**Consultation Response from KC,
Highways Development Management****2025/90621 Westborough WMC, Brunswick Street, Westborough, Dewsbury, WF13 4ND****Outline application for residential development****Date Responded: 07/08/2025****Responding Officer: D. Stainsby****Responding Ref: K14-10SW/28****RECOMMENDATION.**

title SITE PLAN

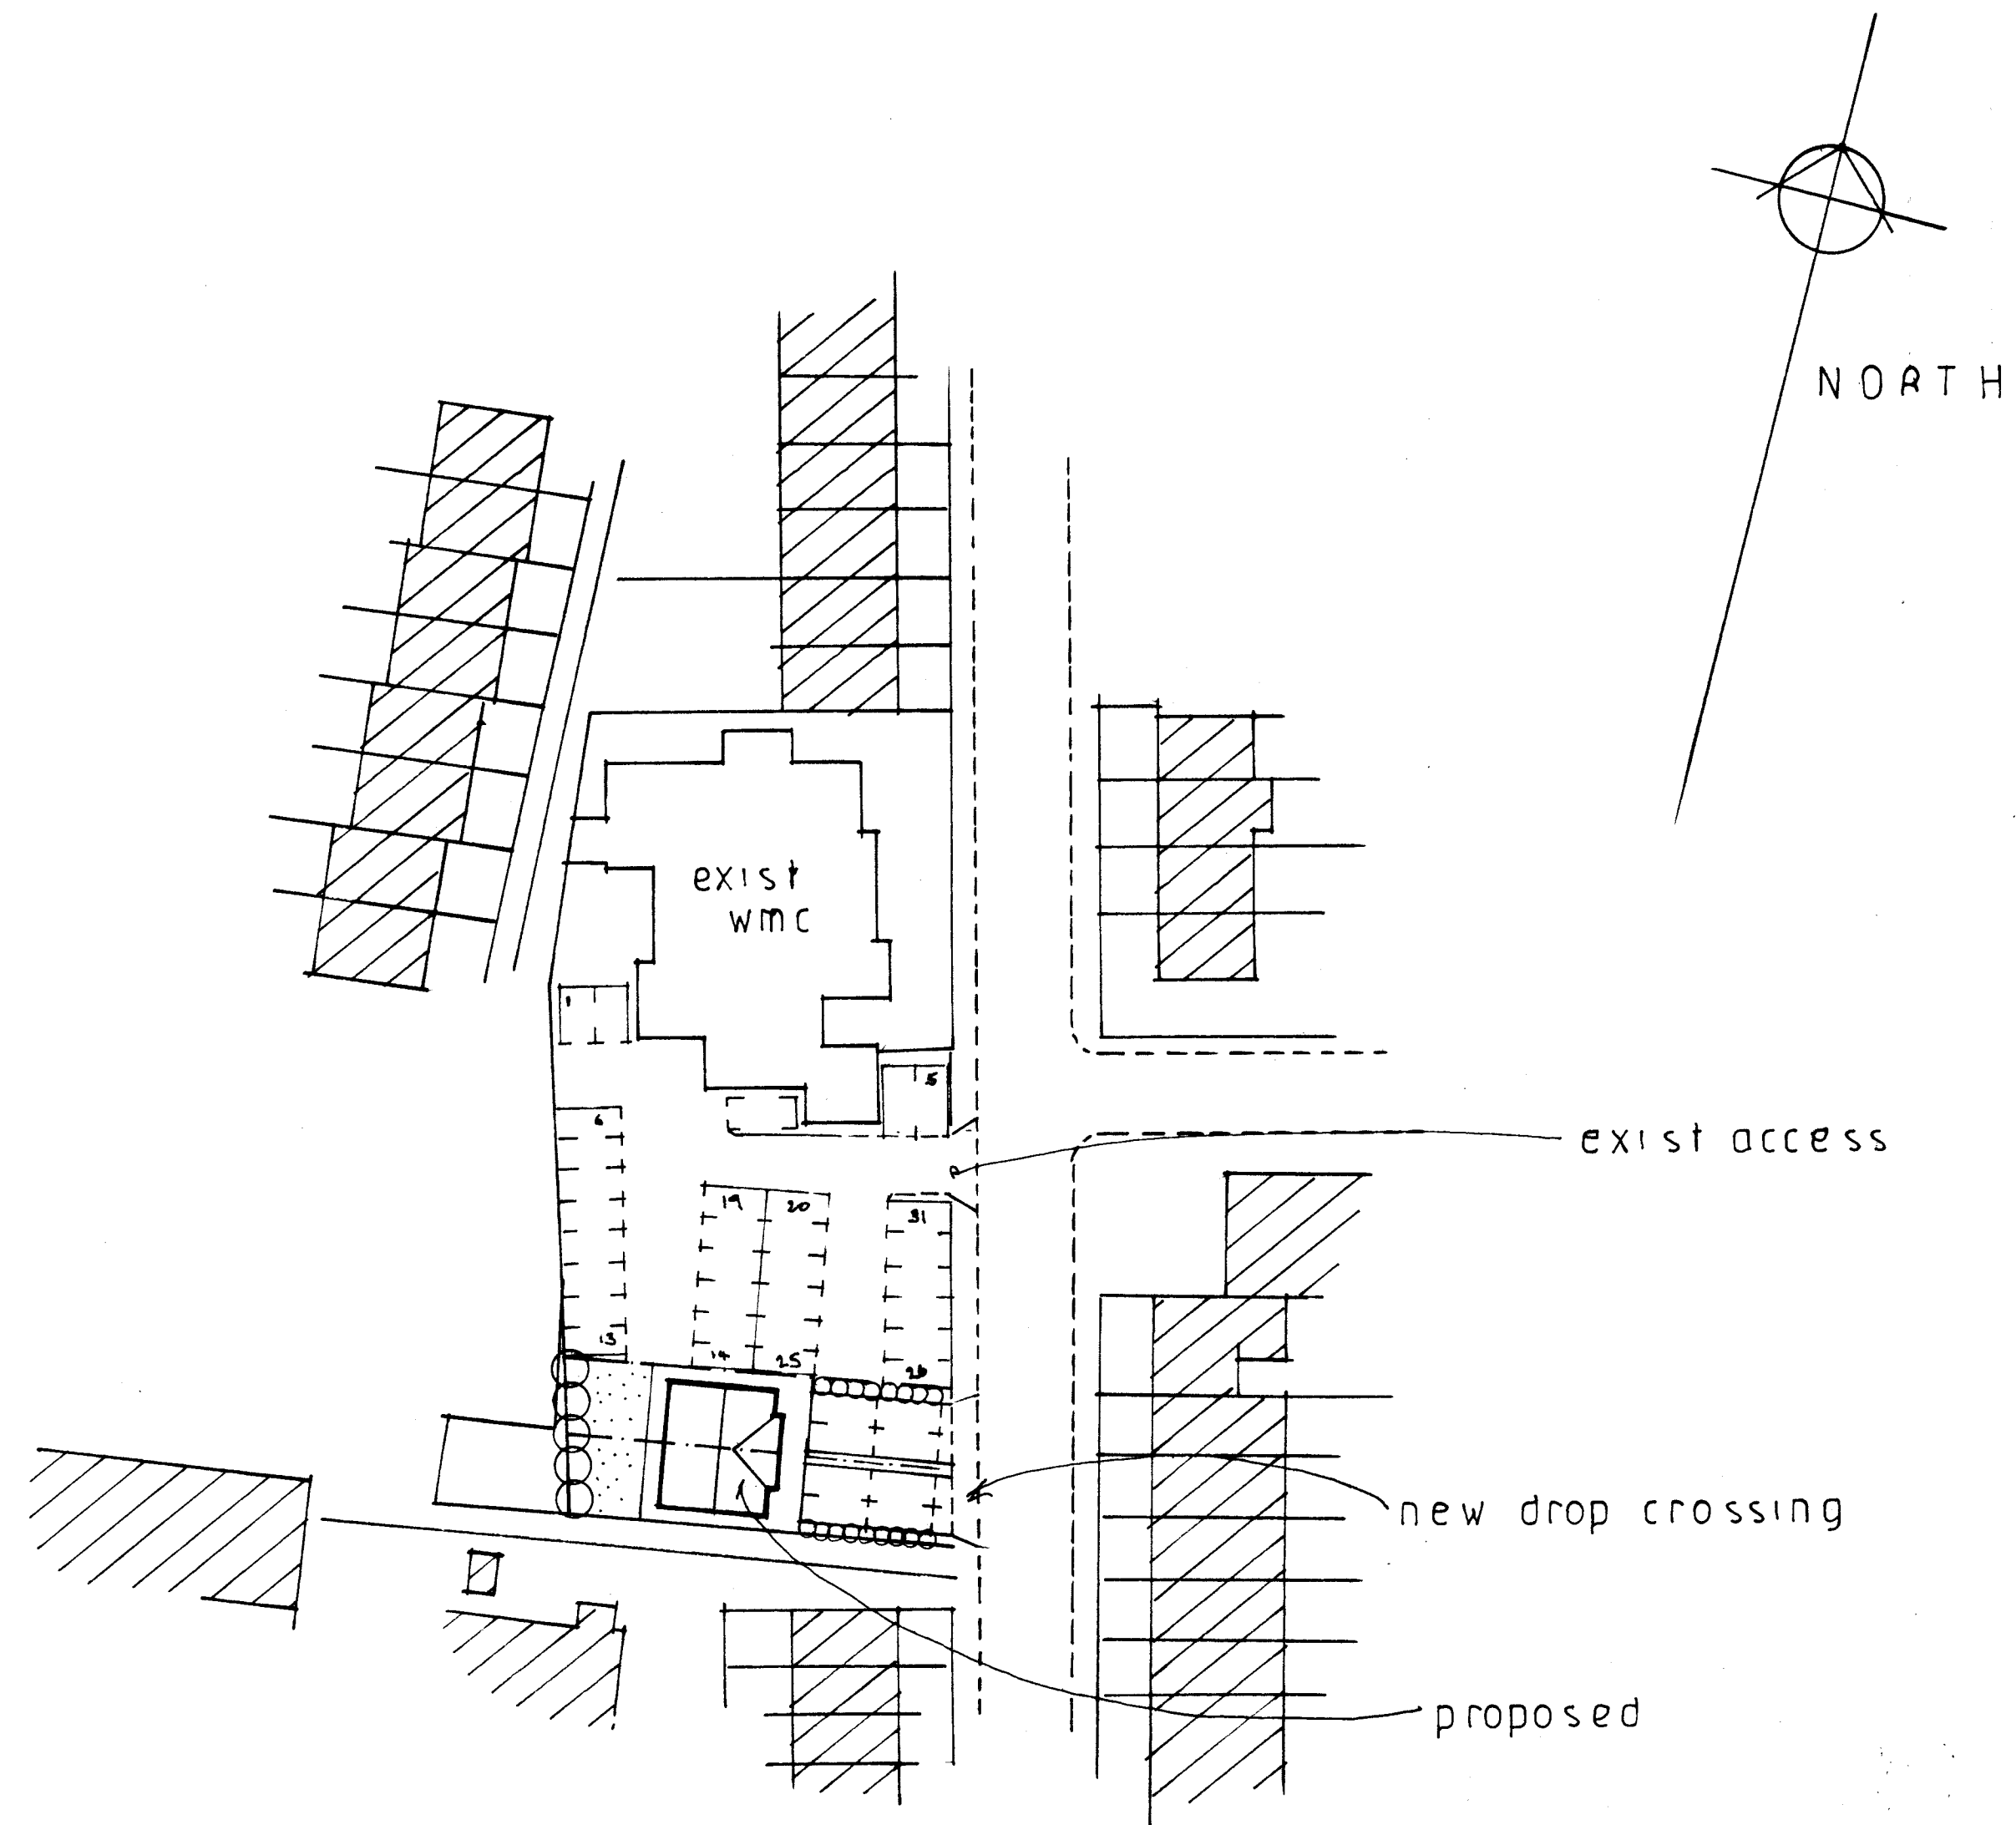
A new access on to Brunswick Street is proposed to accommodate off street parking for the proposed development.

The proposed access will need to be constructed under a section 184 agreement of the 1980 Highways Act (vehicle crossings over footways and verges). You are required to consult the Design Engineer (Kirklees Street Scene: 01484 221000) with regard to obtaining this permission and approval of the construction specification. Interference with the highway without such permission is an offence which could lead to prosecution

Manual for Streets states that for a 30mph speed limit sight lines of 2.4m x 43m should be achievable and demonstrated on a suitable plan. Any shortfall of this requirements should be in accordance with 85%ile wet weather speed readings (if below 30 mph).

The proposal is on the existing car park for the adjacent Westborough WMC and will remove some parking spaces available to the club.

However, 31 car parking spaces will remain for the club and on balance I would consider that this is sufficient to accommodate the clubs' requirements.
